29 March, 2022

Your ref: MP06_0228_Mod 21

**RE: SHOALHAVEN STARCHES EXPANSION PROJECT - MODIFICATION 21
 REVISED PLANS**

P.C.	DATE	SHOALHAVEN STARCHES.		SHT SIZE
CHKD JS	25/08/20	NORTH PACKER MOD 21.		A3
APPD	DATE	SECTIONAL ELEVATIONS.		REV.
	SCALE	PROJECT No.	DWG No.	P02
	1:600	7323-020	MN7323-020

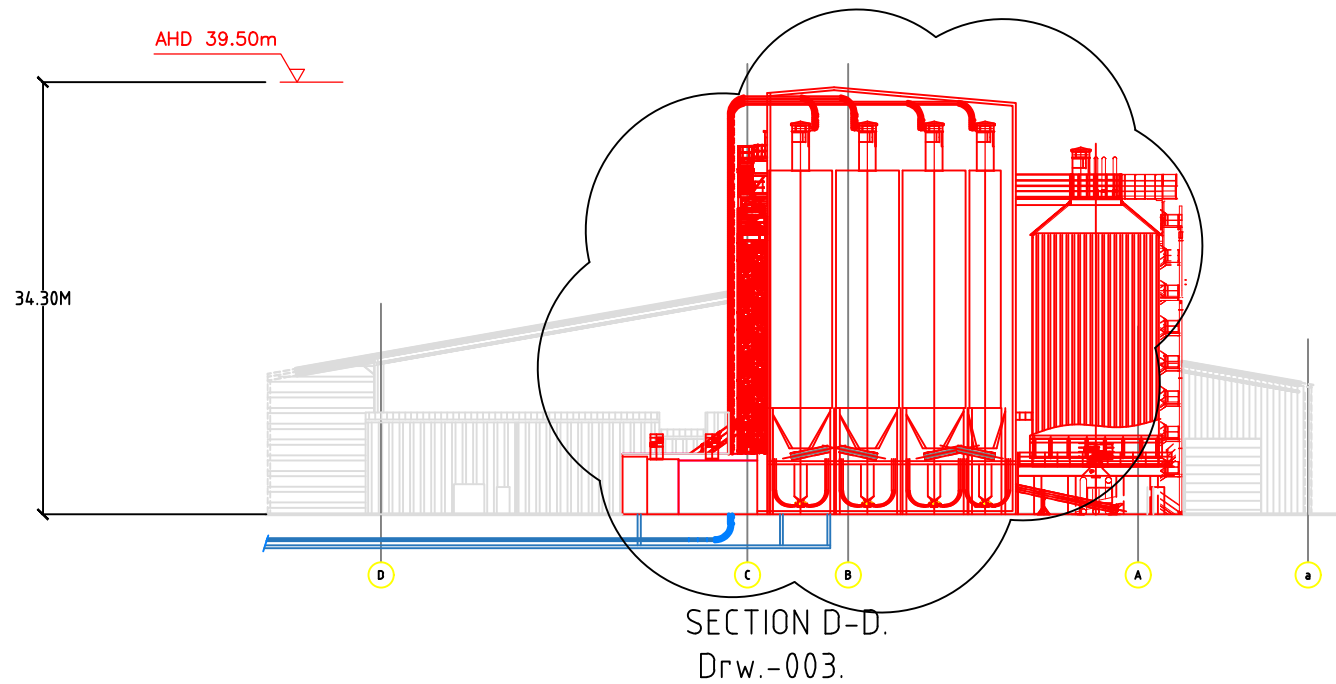
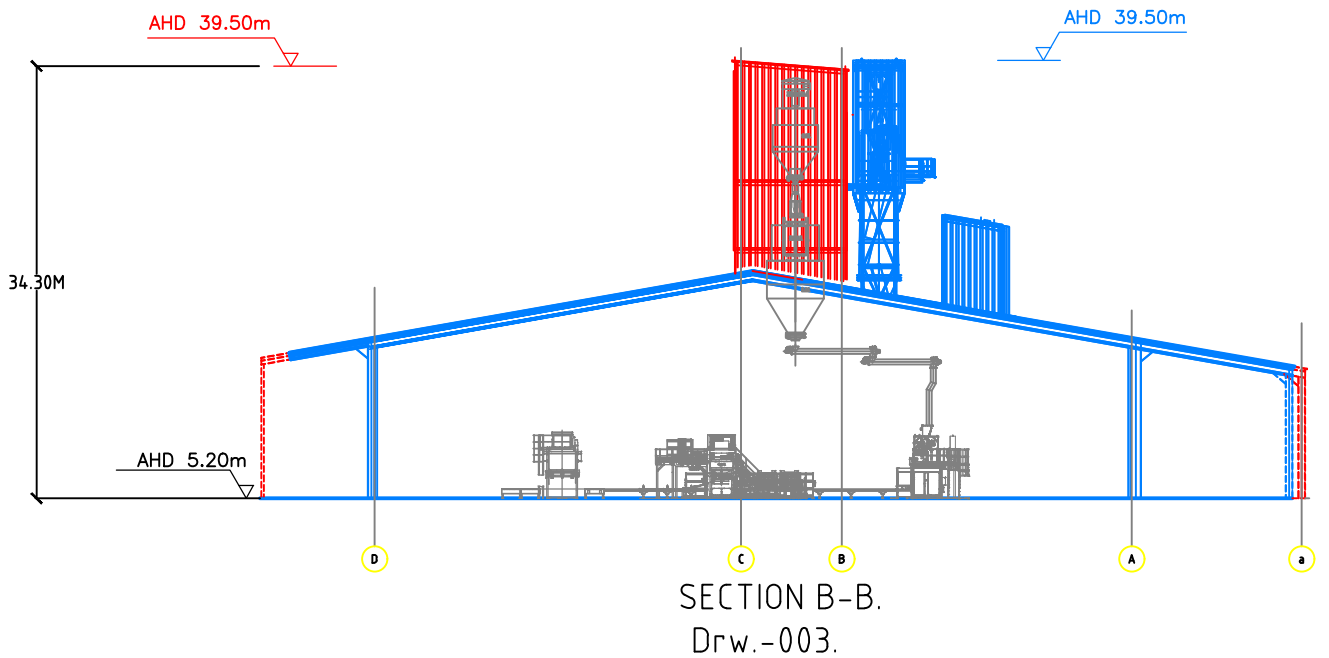
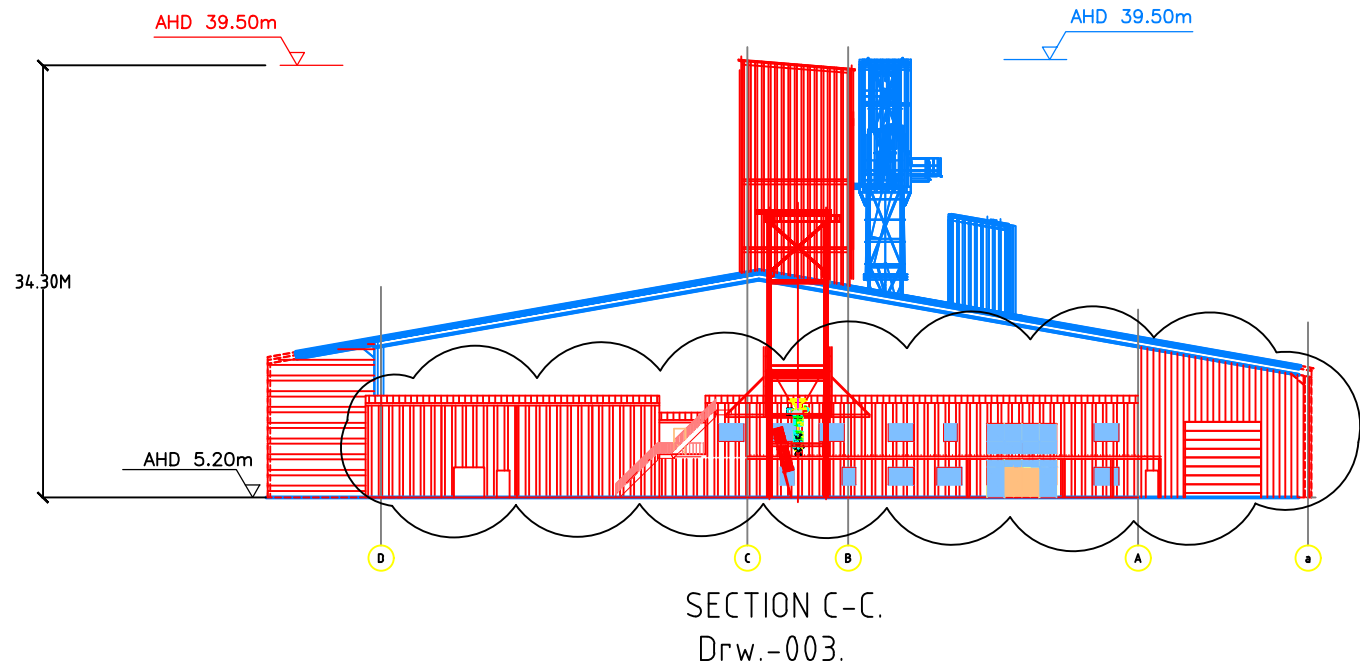
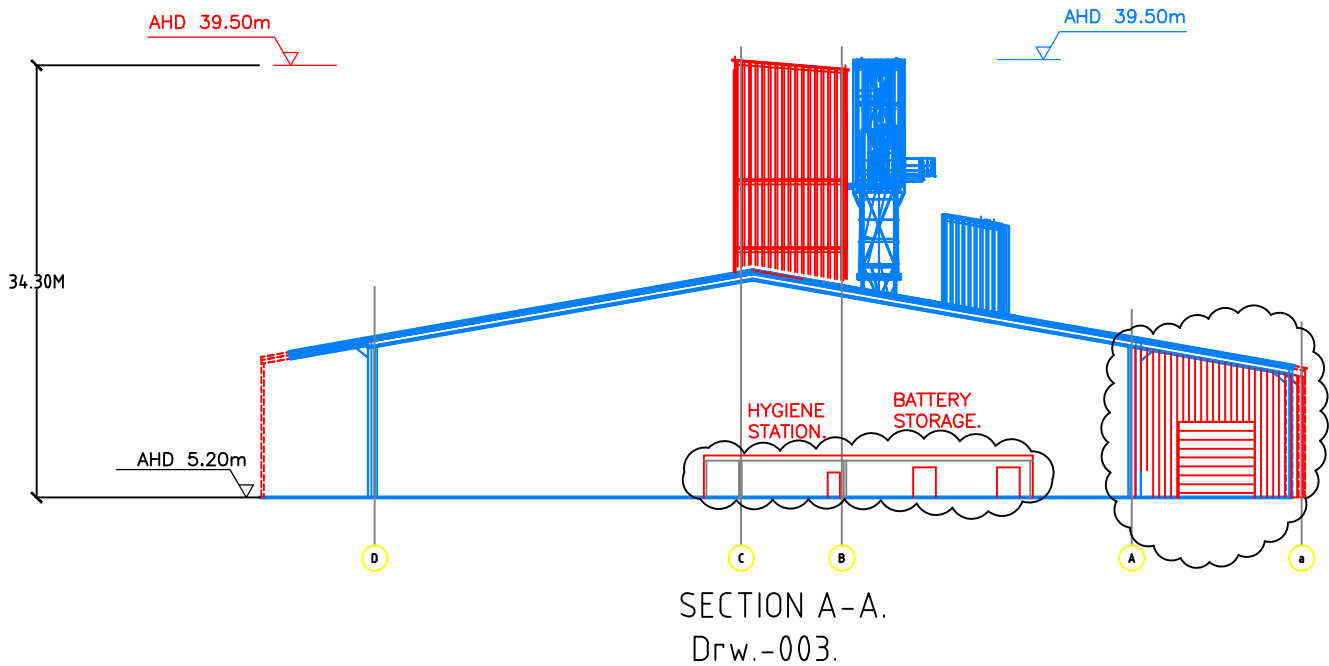
7323-020		P02	North Packing Sectional Western Elevation	Additional elevations showing doors and windows	Additional design clarification to aid with the Construction Certification.
7323-021		P1	Packaging/Warehouse building plan views	Additional roof design plans Additional floor design plans	Additional design clarification to aid with the Construction certification. Additional design clarification to aid with the Construction certification.
19042-DE-004		D	Fork Battery room arrangement		Additional design clarification to aid with the Construction certification.
